**WEST SUSSEX COUNTY COUNCIL
STRATEGIC PLANNING CONSULTATION**

DATE: 11th December 2012

SUBJECT: A/82/12 - Residential development comprising 150 x dwellings including 30% affordable with access, landscaping, open space & associated works (this application is a Departure from the Development Plan).

LOCATION: Land East Of, Roundstone Lane, Angmering, West Sussex, BN16 4AL

Appendix 2
Roundstone Lane Roundabout Plan
and Photographs

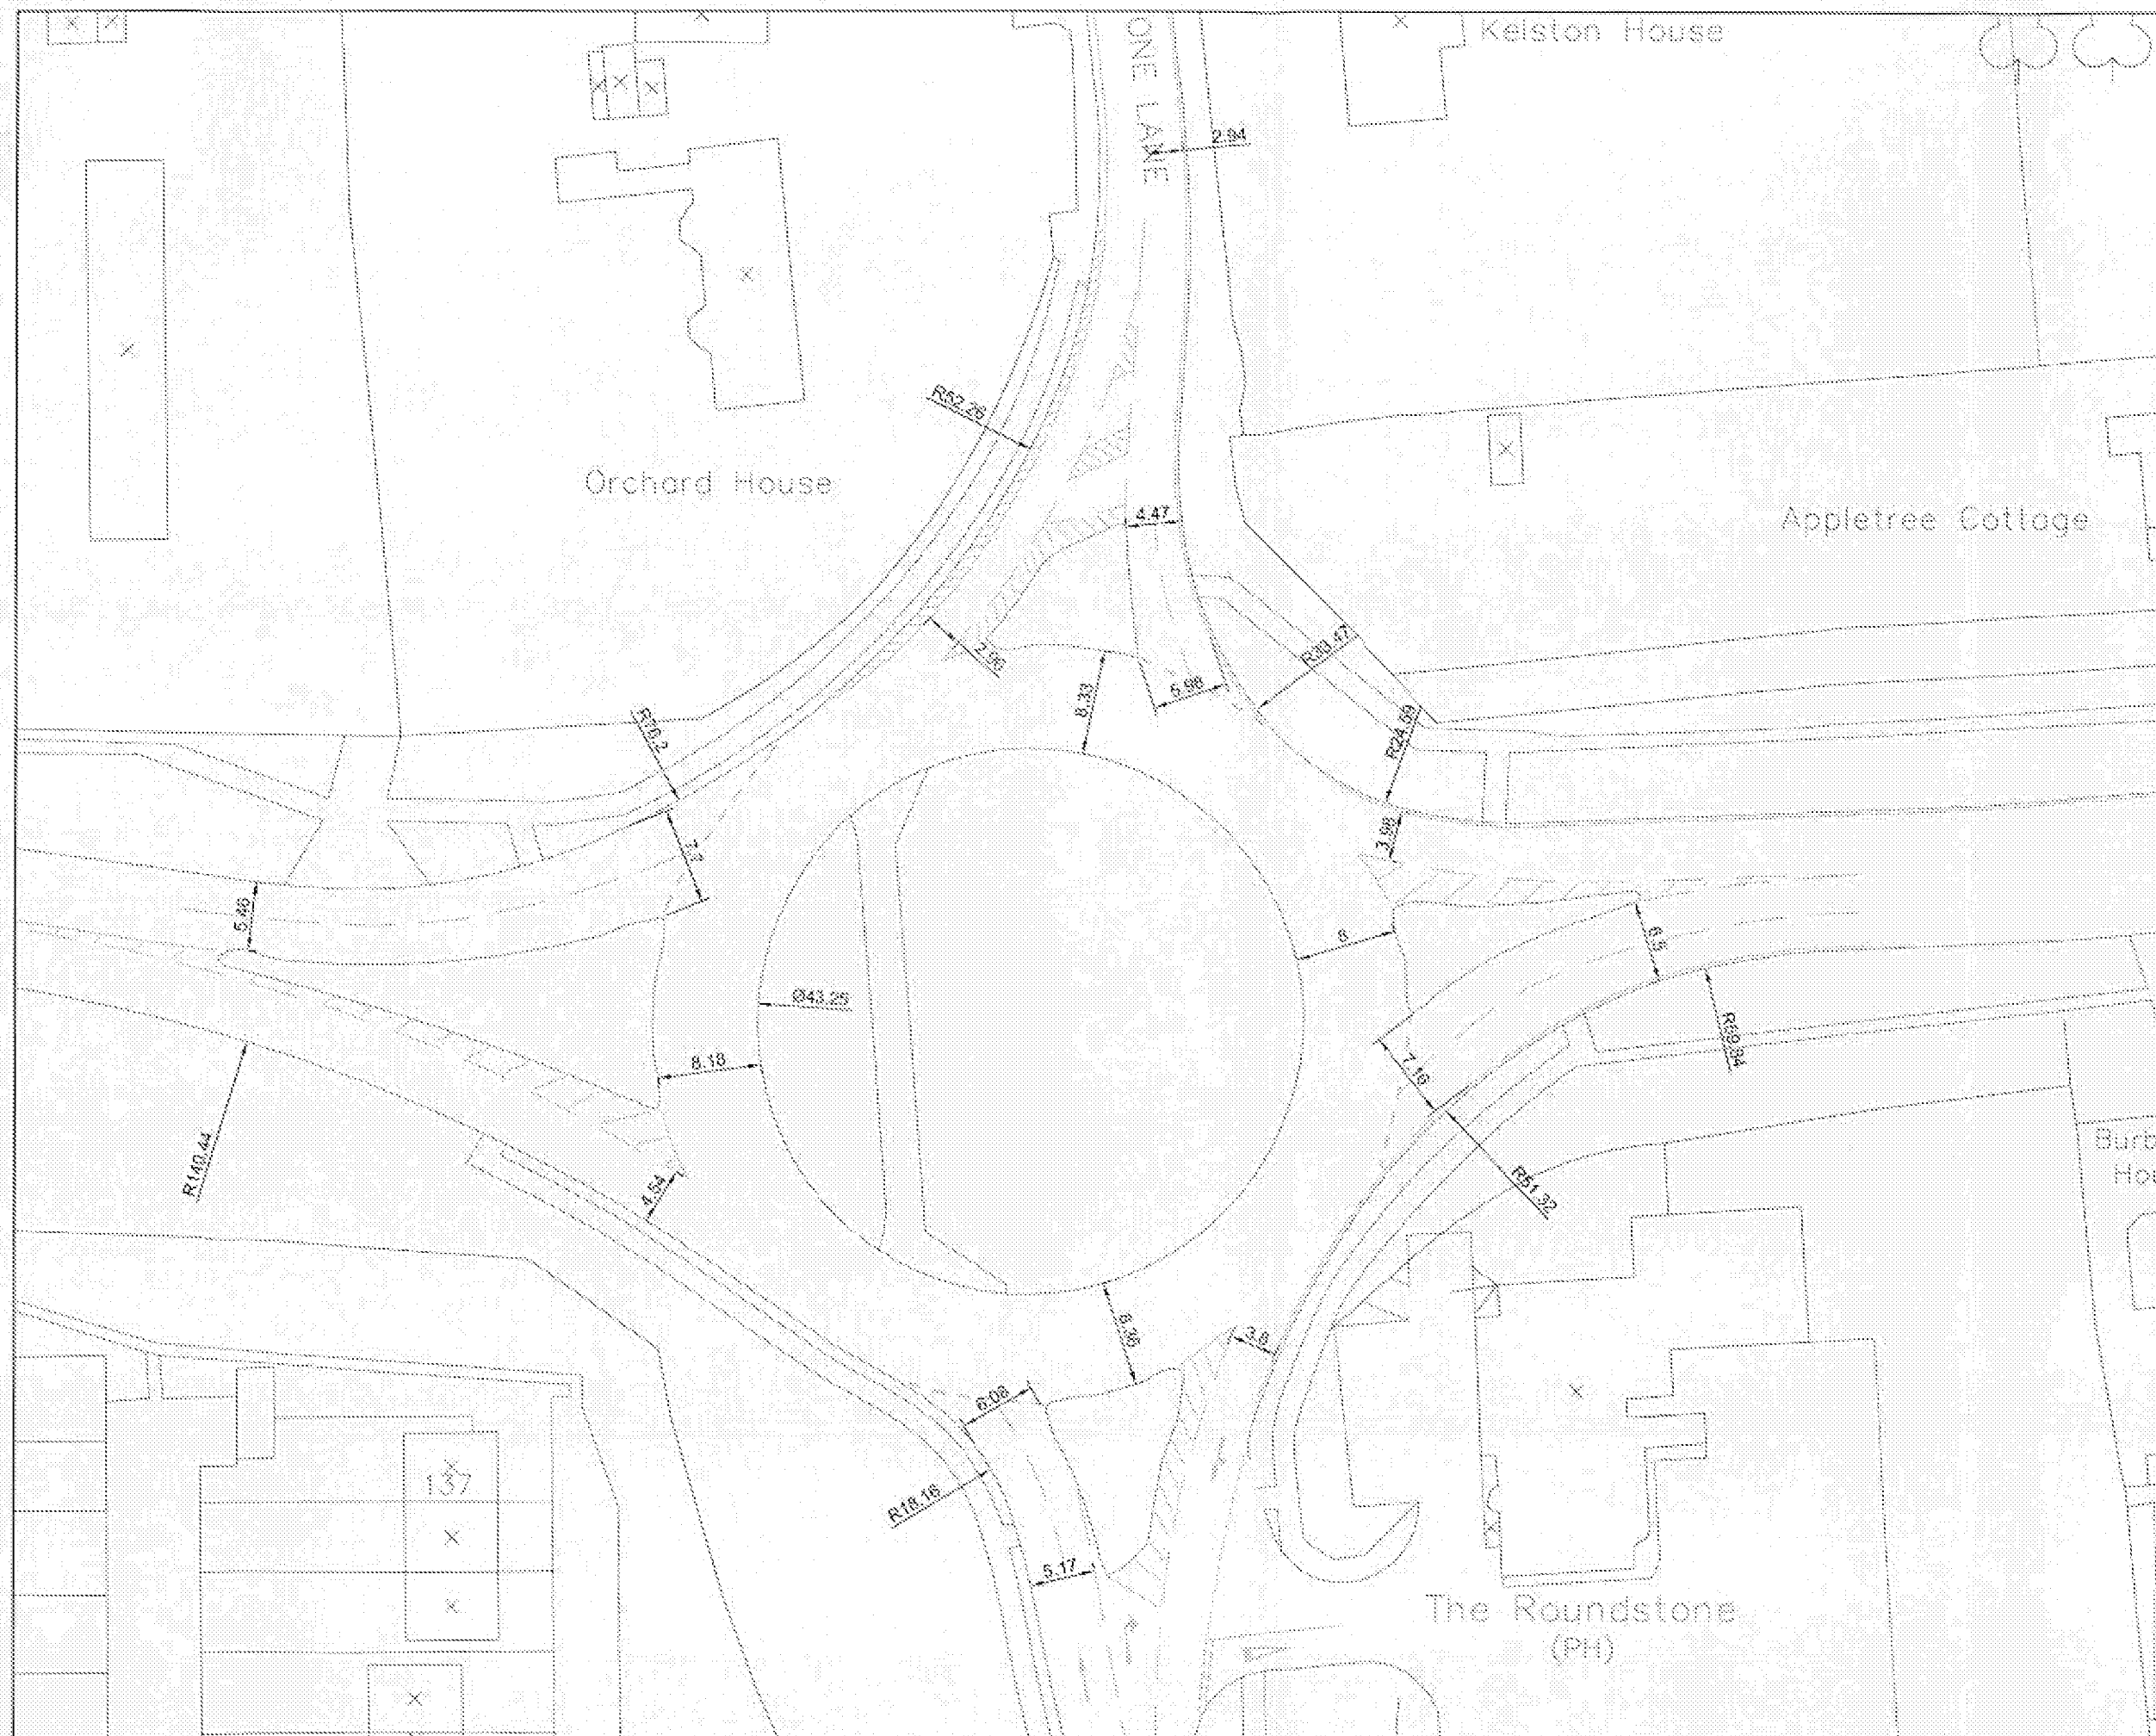
The junction of the A259 with Roundstone Lane appears to have a narrow exit arm from Roundstone Lane which appears to reduce capacity on the arm, particularly when large vehicles attempt to leave Roundstone Lane to join the A259. Some overriding of the grass verge on the nearside of the northern arm is evident in the form of tyre track markings. Further information has been provided by the applicant's highway consultant, including a video survey on the junction functioning in the peak periods. On-site observation (during the am peak period on 27th November 2012 by the Highway Authority) revealed a maximum queue on the northern arm of Roundstone Lane of approximately 9 No. vehicles, albeit brought about because a coach was observed straddling the white lines at the junction. Average queues observed by the Highway Authority were approximately 4 vehicles during the am peak which is higher than the recordings in Appendix 1 of the aforementioned Technical Report of 23rd November 2012. Vehicles were observed getting away from the junction relatively quickly as gaps on the roundabout became available regularly.

Turning to the surveys and the revised ARCADY assessments provided in the Technical Report, some discrepancies were found, particularly with the ARCADY reports for the Roundstone Lane/Littlehampton Road (A259). In particular, the dimensions inputted to the ARCADY programme were different to those set out on Drawing No. 110 produced by the consultant. This should be corrected and the ARCADY re-run for this junction. Furthermore, drawings should also be provided for the A280/Littlehampton Road (A259) and Station Road/Littlehampton Road junctions with ARCADY re-run for these junctions, in order that the Highway Authority can check these as well.
